Re: PHASE 1 Salazar Lands Subdivision- Sketch Plat Submittal

Enclosed for Development Facilitation Team (DFT) sketch plat review and comment are copies of the following information:

PHASE 1 SITE PLAN EXHIBIT

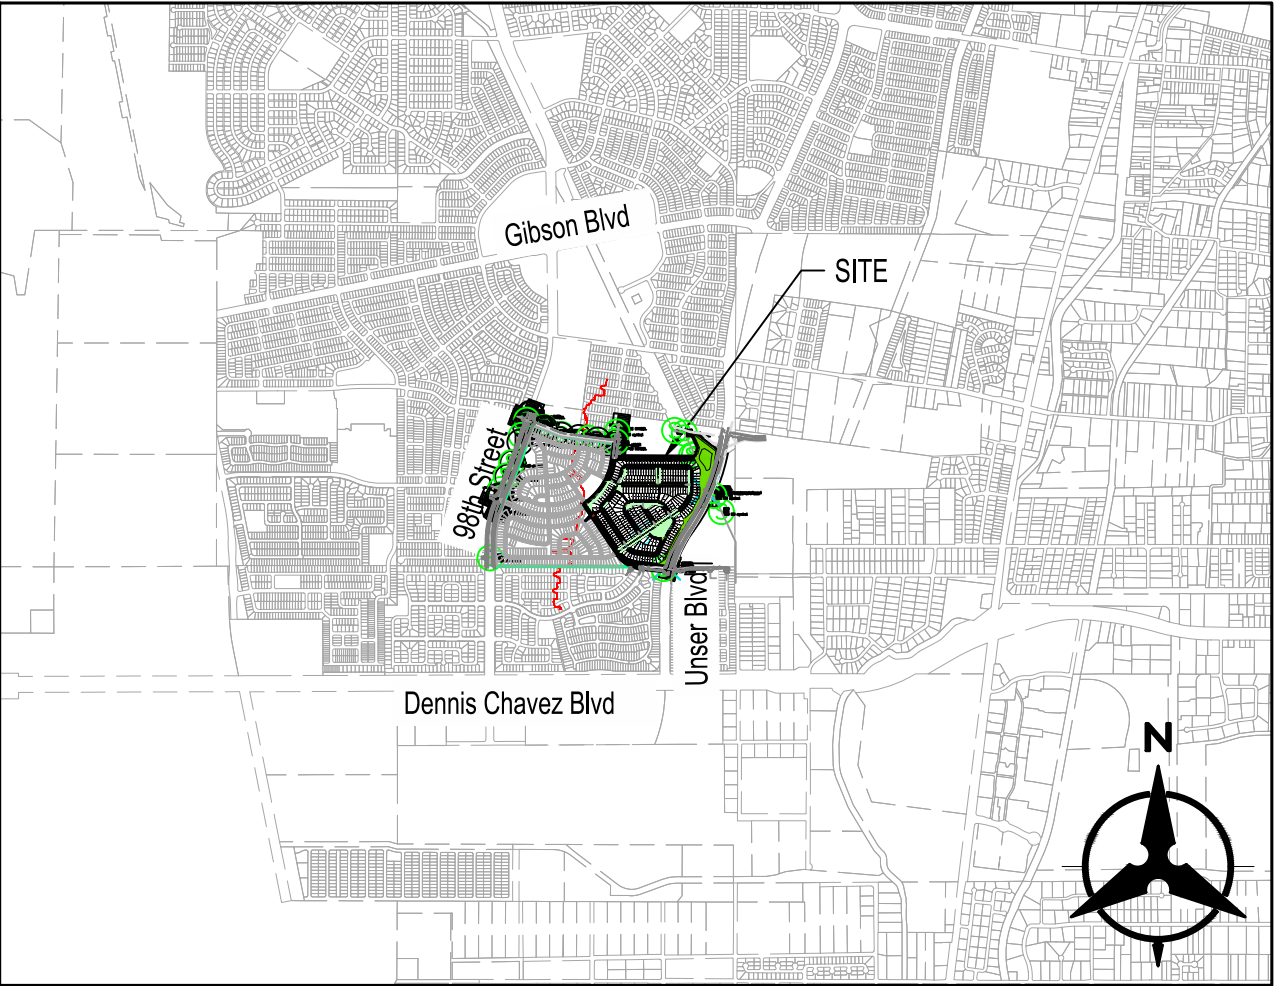
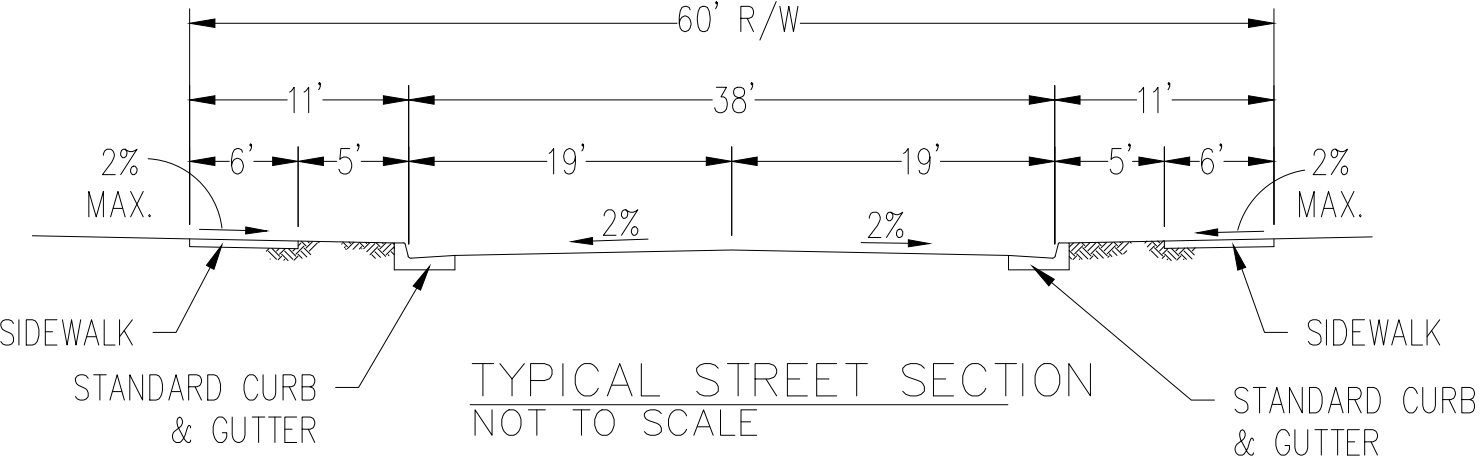
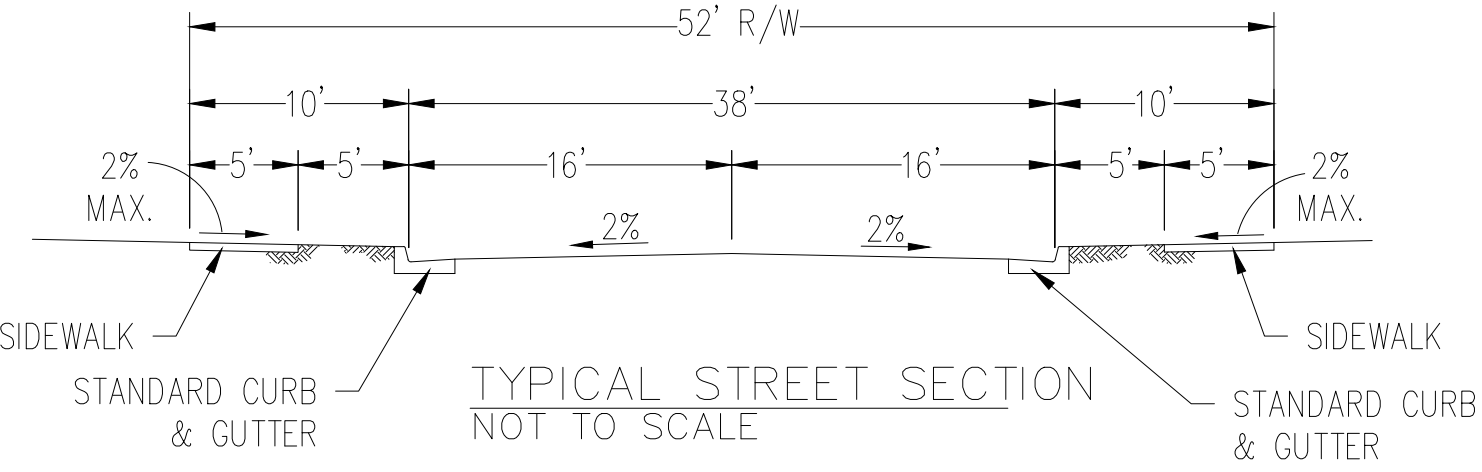
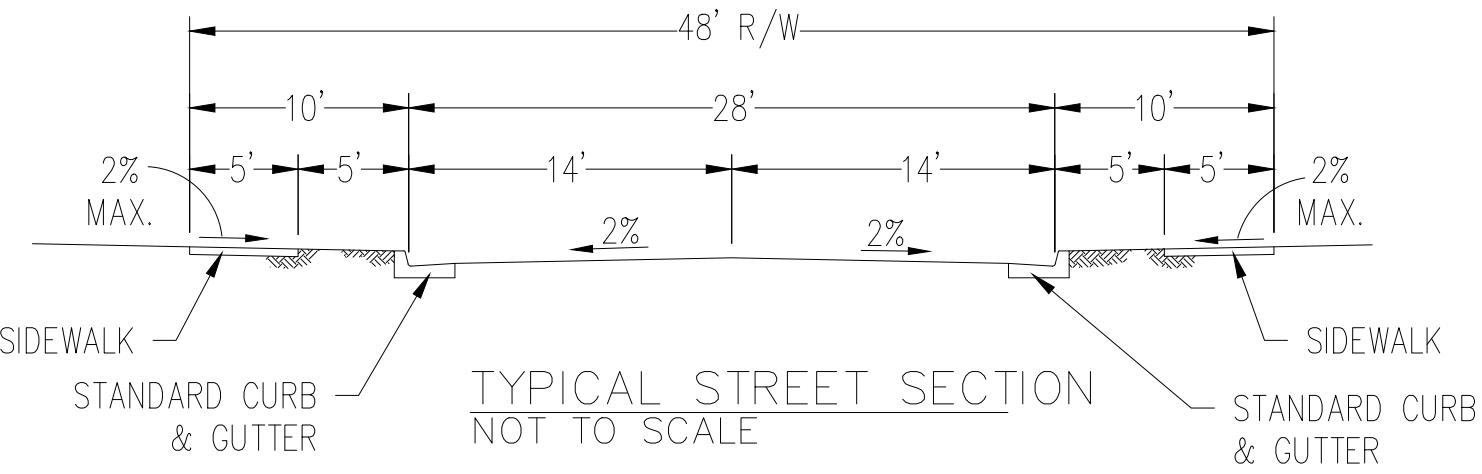
1. Will there be any necessary improvements or modifications to Unser Blvd to accommodate the new subdivision, especially at the points of ingress and egress?
2. Are there any required infrastructure improvements along Anderson Hill Ave, Vermejo Park Dr, or Unser Blvd?
3. Is this portion of Unser Blvd owned and maintained by the NMDOT or the COA?
4. We are aware there is an AMAFCA drainage ROW and FEMA floodplains on the site. We have coordinated with AFMFCA and vacated the portion of ROW through

CONCEPTUAL UTILITIES EXHIBIT

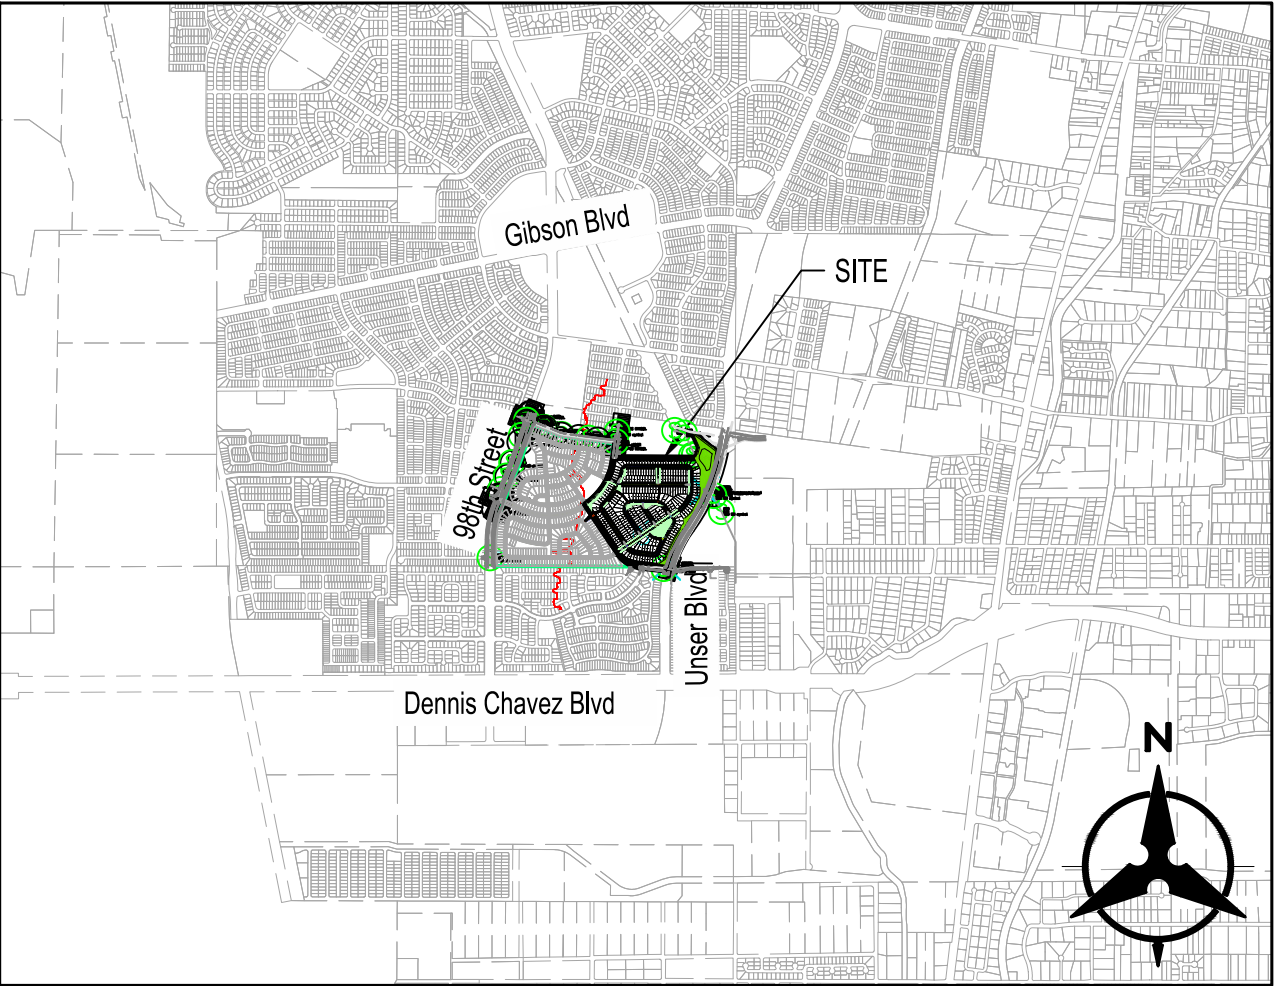
5. We are in the process of submitting a Water/Sewer Availability to ABCWUA.
  - a. Overall, the site drains due east towards the Ex 27" SAS line. Additionally, there is an existing 12" SAS line in the southeast corner in Anderson Hills. Are there any stubs located off the 27" SAS line? Will the site otherwise be able to connect to this 27" line and/or will we be able to drainage towards the 12" line in Anderson Hills.

- b. The site is also located in two pressure zones (2WR and 1WR). For Phase 1, pending final grading, it is assumed the site will be serviced by the 1WR water line that can be looped with two connections to the existing 12" WL in Unser. A 2WR waterline will also be constructed for the future phase connections. (With future phases, the 2WR water is assumed to be looped through the 2WR waterline in Unser and the 2WR waterline Amole Mesa/Vermiejo. Will there be a need for a PRV with this development?
